Re. Planning application 3/2025/0114

Being the most affected by this application [REDACTED] we wish to register our objection to it. The builder who has bought it to renovate, and presumably sell for the maximum profit he can get, plans to almost double the size of the property with large dormers that look directly out from each side, rather than facing the road. Whilst many bungalows on this estate have already had dormers fitted, they are generally of a much smaller scale and facing the road.

PROPOSED
FIRST FLOOR PLAN

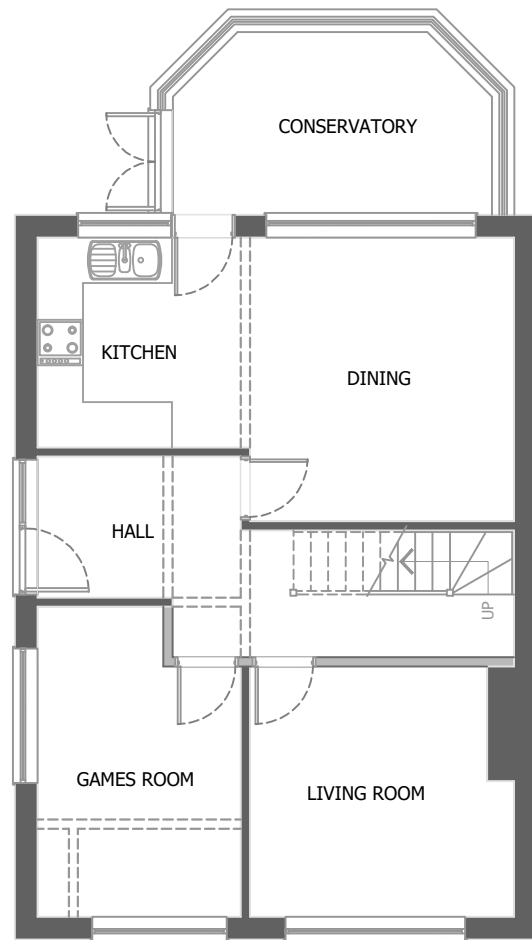
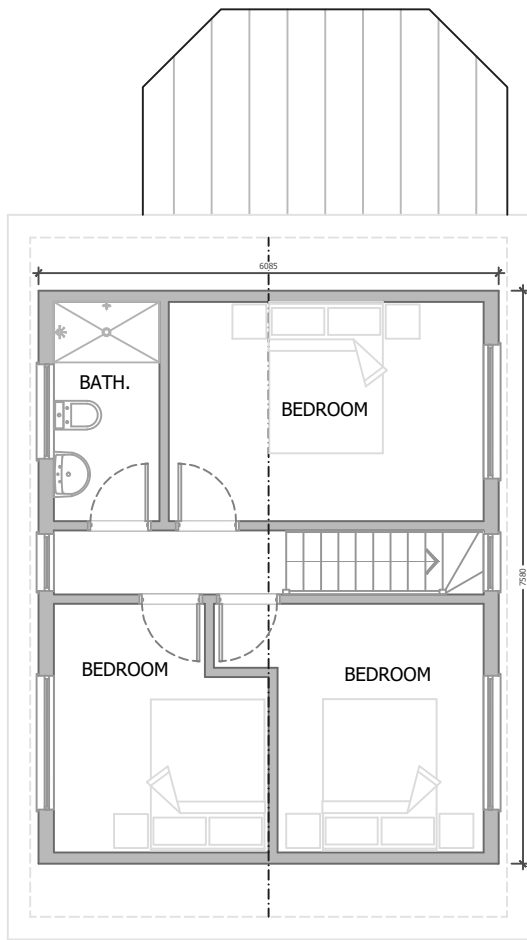
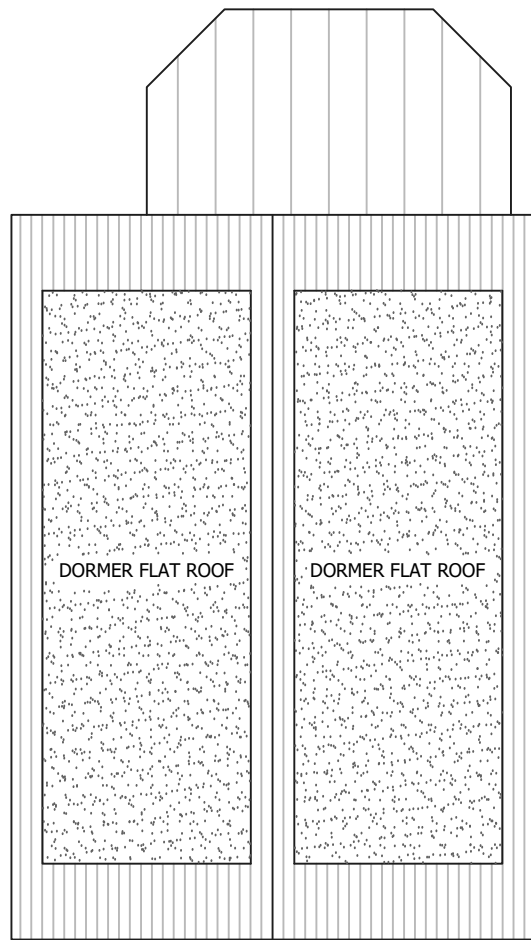
If this project went ahead it would feel like the property would totally [REDACTED] and completely remove any feeling of [REDACTED]. These bungalows were generally built to give a degree of privacy, with door and windows on just one of the sides, facing the plain brick wall of the adjacent property. The proposed dormer windows of this property would [REDACTED] as well as looking totally out of proportion to the original concept of these bungalows. It would essentially become a 2 storey house. The dormer would also reduce the amount of daylight [REDACTED]

[REDACTED] to the incline of Kirkdale Road, and with a roof planned to be higher than it is now. I attach photos to show the proximity of the bungalows concerned. Whilst our view [REDACTED] attractive, the proposed increase in height, with windows directly above us, would feel oppressive and intimidating.
